Tuesday, April 19, 2022

Matt Grush, P.E., Senior Traffic Engineer
Transportation Development Section
City of Albuquerque Planning Department
600 Second St. NW
Albuquerque, New Mexico 87102

Re: Oxbow Development / Coors Pavilion (St. Josephs Dr. / Coors Blvd.)

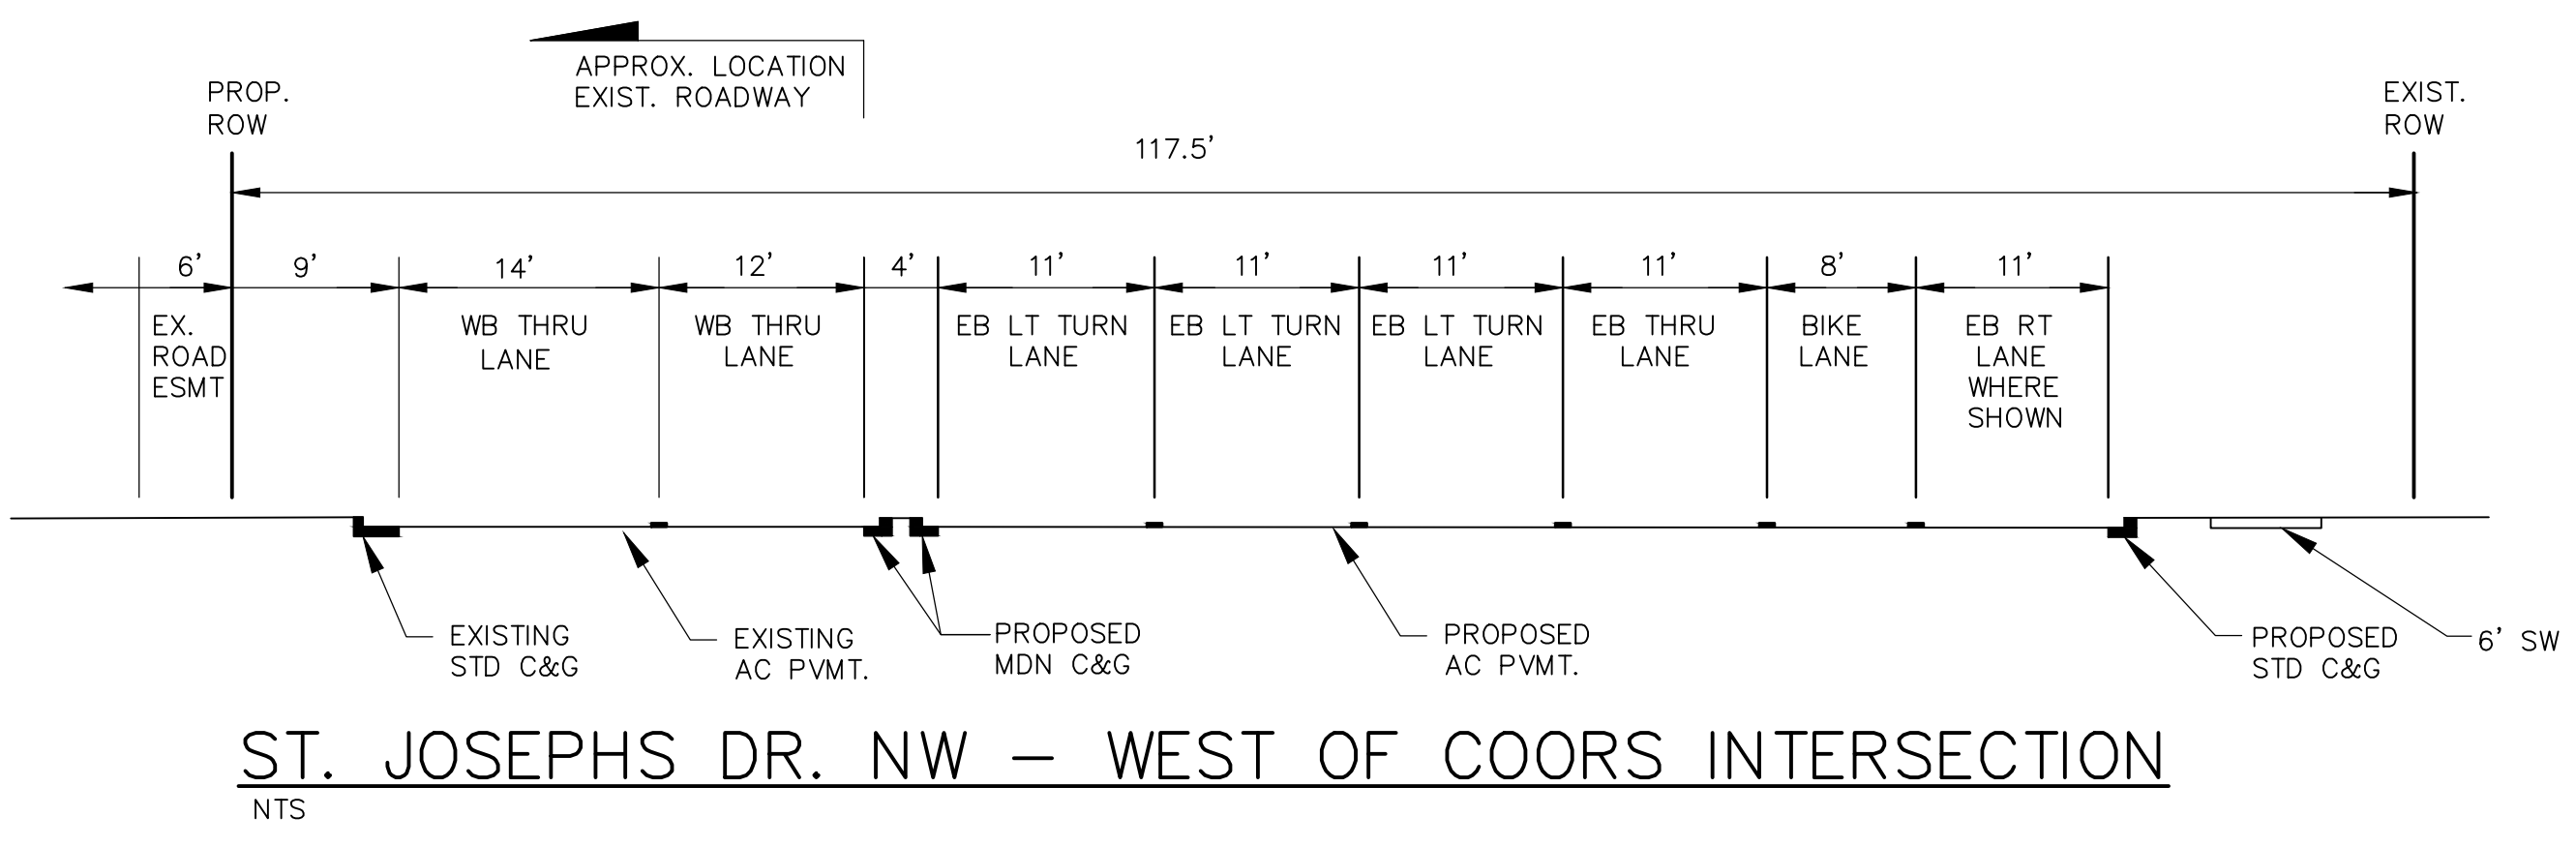
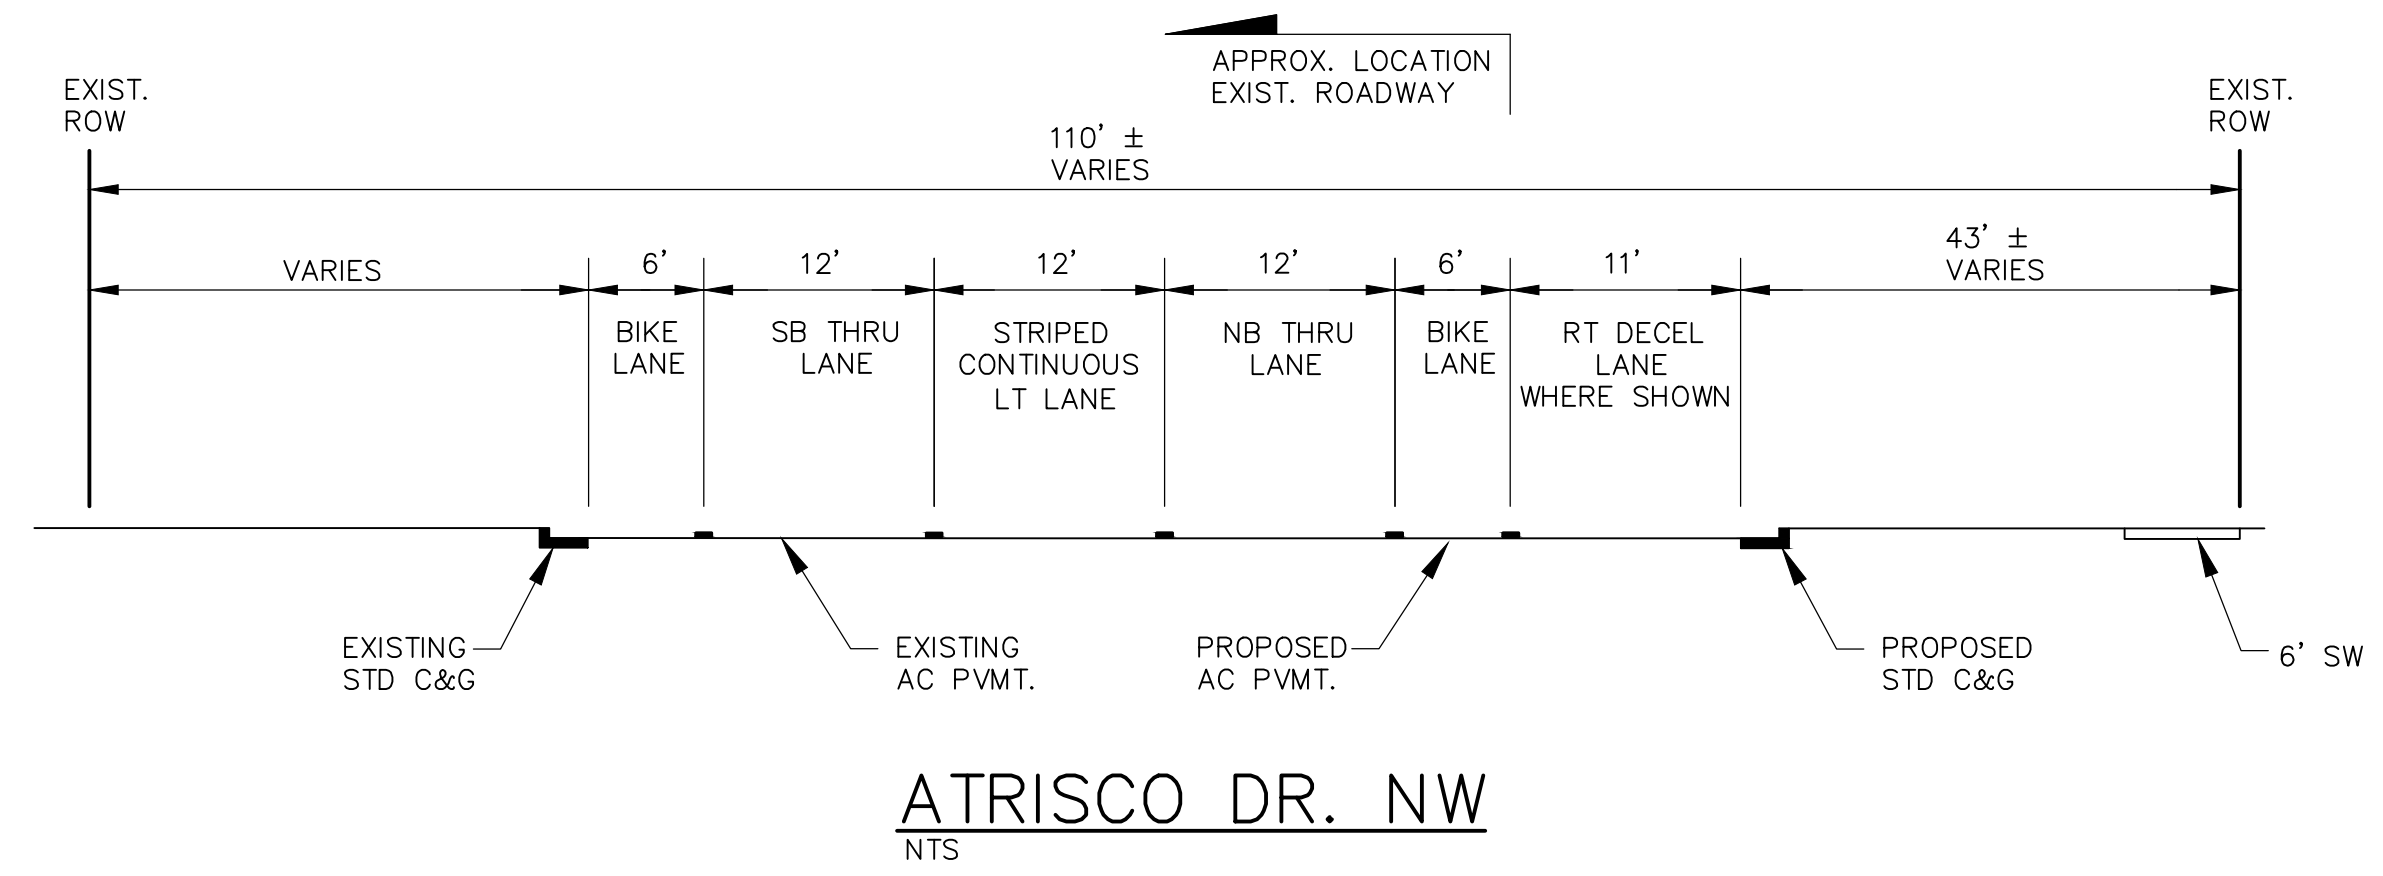
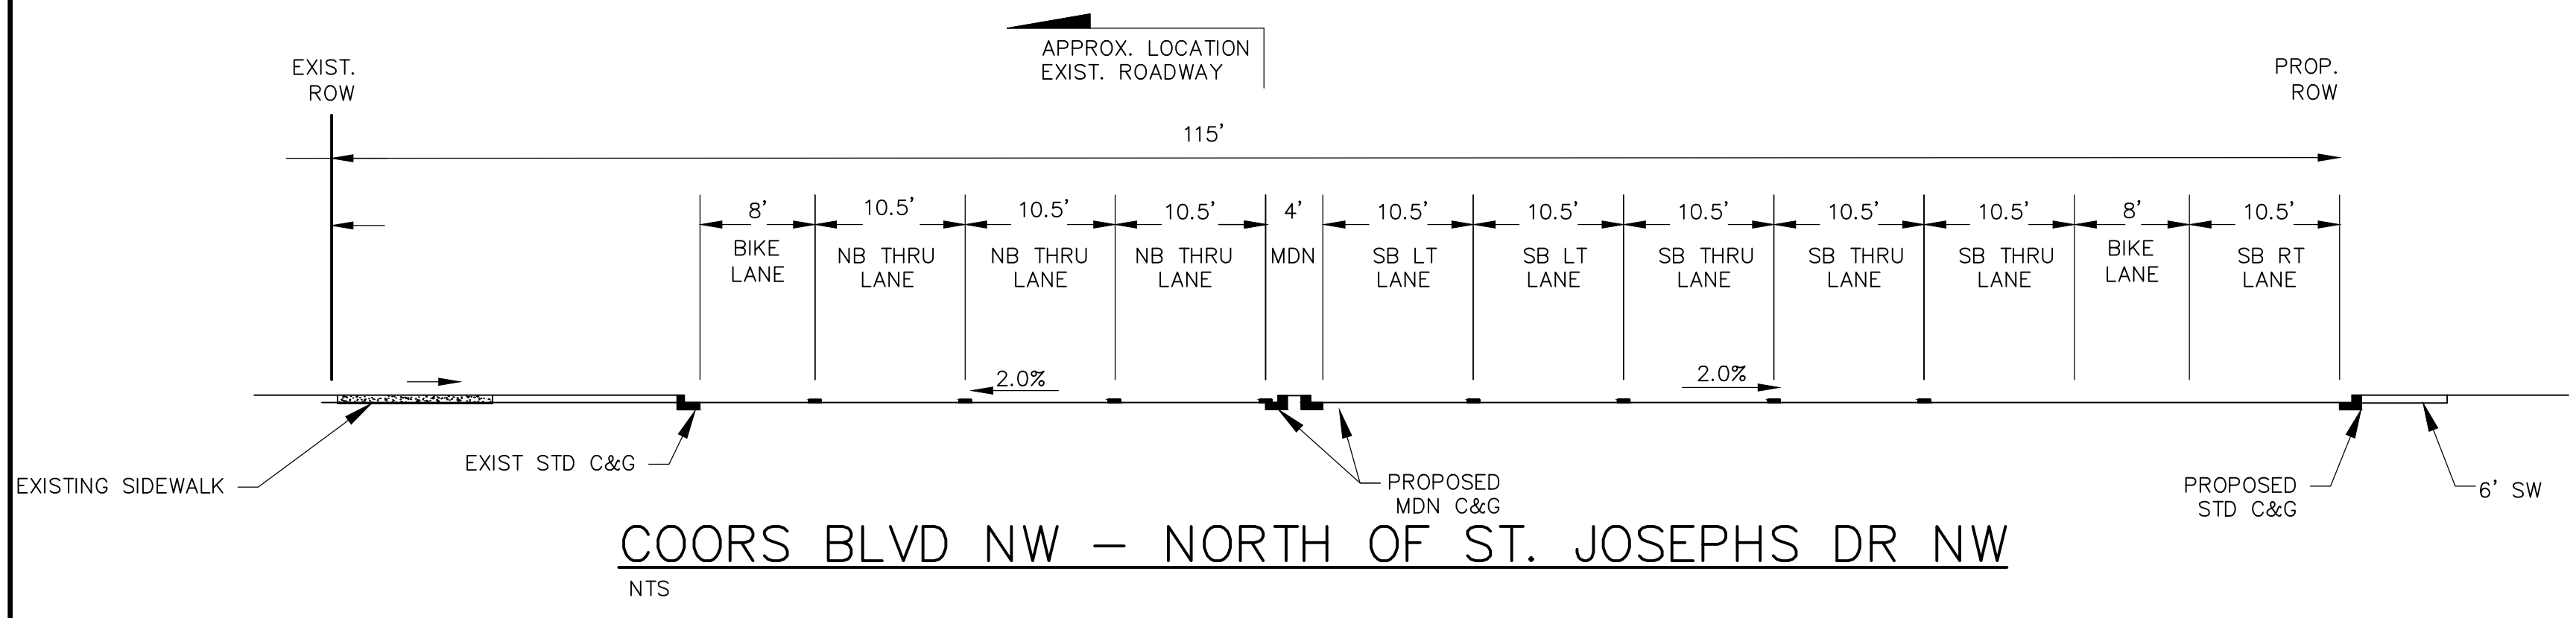
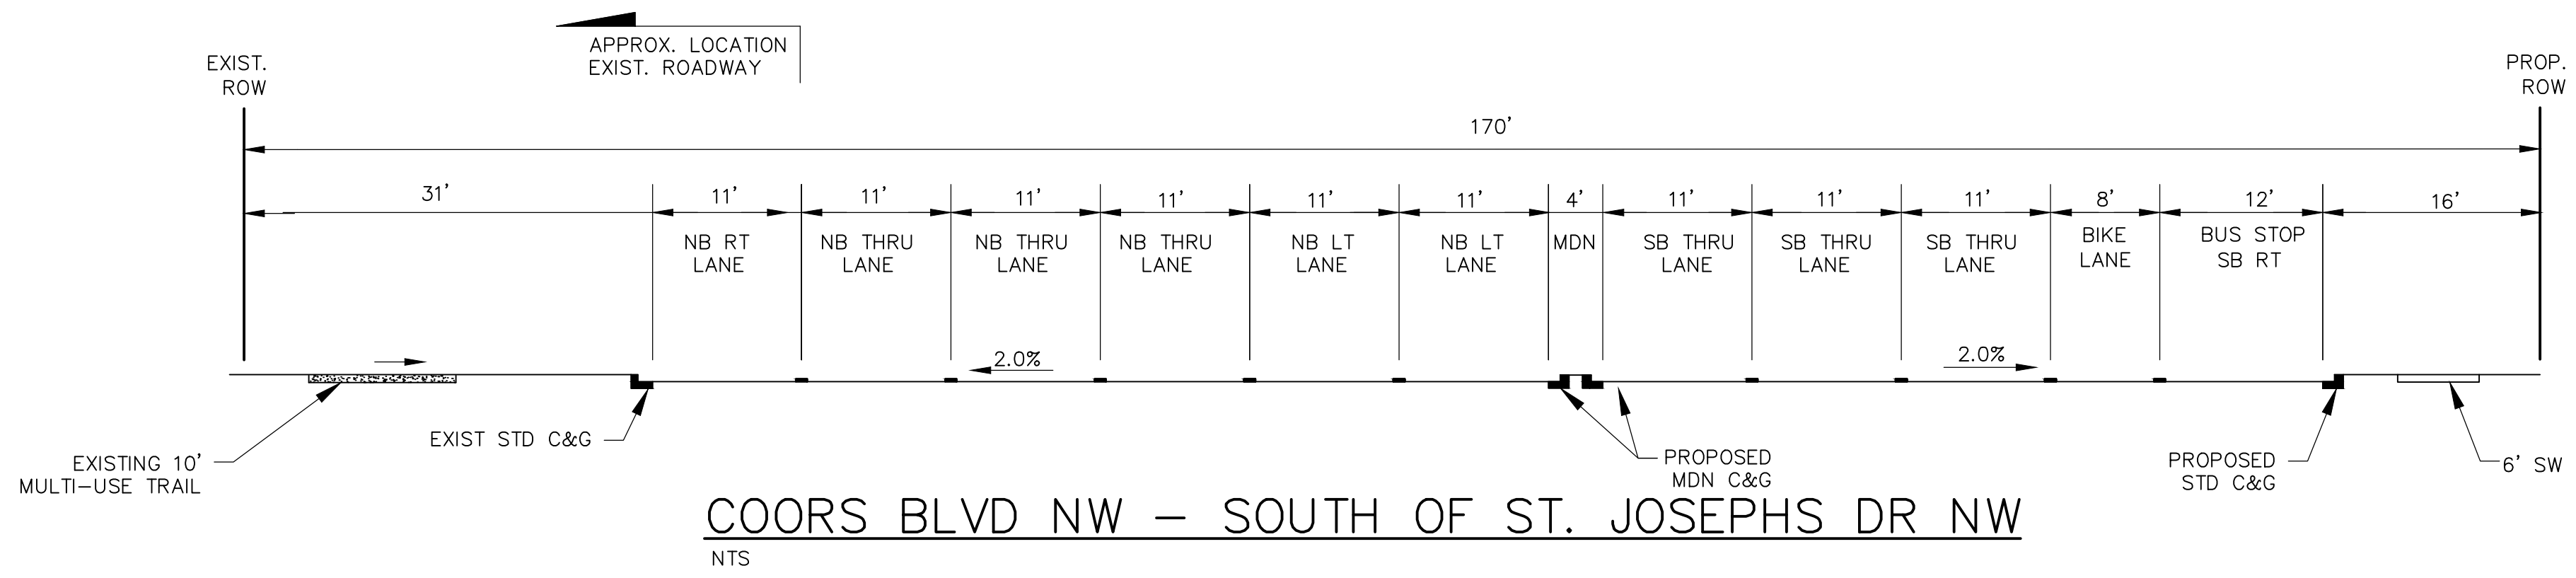
Comment: Provide a conceptual footprint to determine the available ROW and what unforeseen infrastructure impacts are anticipated i.e. traffic signal modifications / relocation ...

Comment: Add eastbound bicycle lane with buffer to the cross-section.

Comment: Provide a conceptual footprint of the main entrance to show that it will fit in the existing ROW. Add the eastbound bicycle lane with buffer.

Response: Attached is a graphic conceptual roadway plan developed by Sheldon Greer, P.E. at RESPEC Engineering that demonstrated sufficient ROW available for the recommendations in the TIS.

Response: We acknowledge that the developer will be required to construct St. Josephs Dr. from Atrisco Dr. to Coors Blvd. to meet all of the City of Albuquerque's Design Standards in the Development Process Manual including bicycle lanes.

Response: The attached graphical conceptual roadway plan demonstrates that the main entrance will fit in existing ROW and an eastbound bicycle lane is shown.
